CITY OF ALBUQUERQUE

August 26, 2013

**Re: Garcia's Food Preparation and Warehouse
Grading and Drainage Plan
Engineer's Stamp Date 8-19-13 (J13D096)**

GRADING AND DRAINAGE PLAN

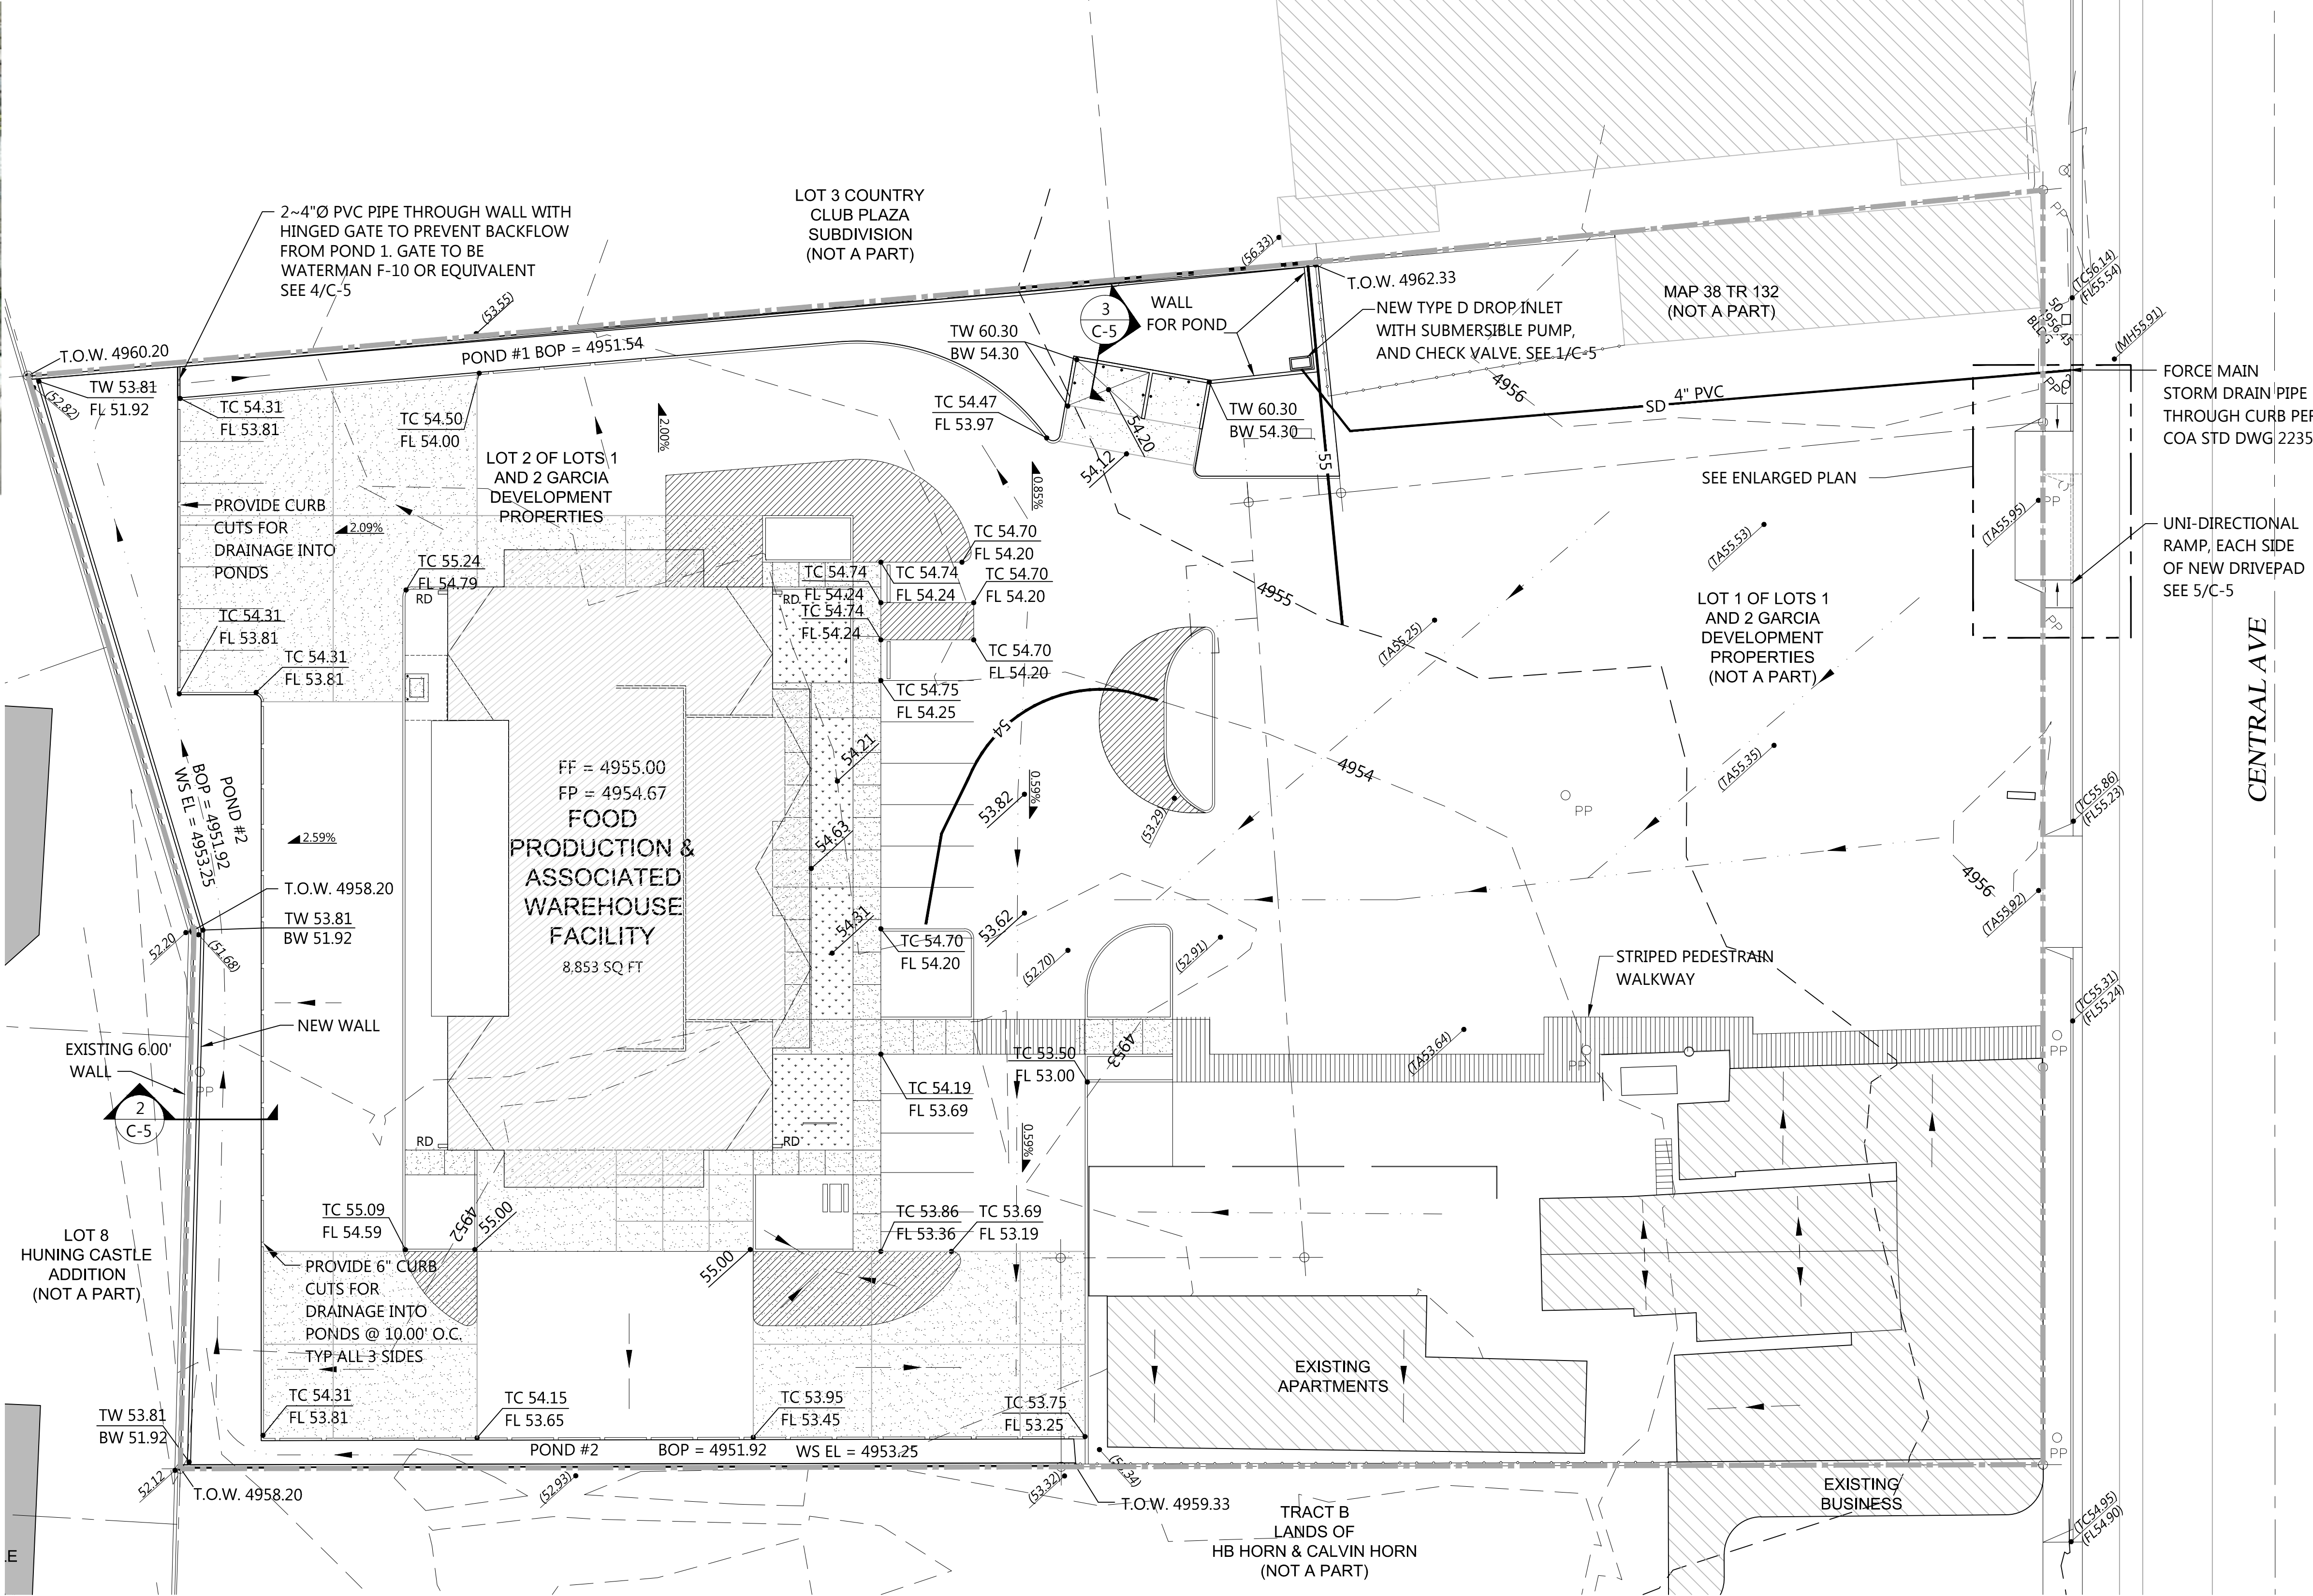
- Since the pond does not show a spillway, provide the 100-yr 10 day water surface elevation on the site and the top of perimeter wall elevation.
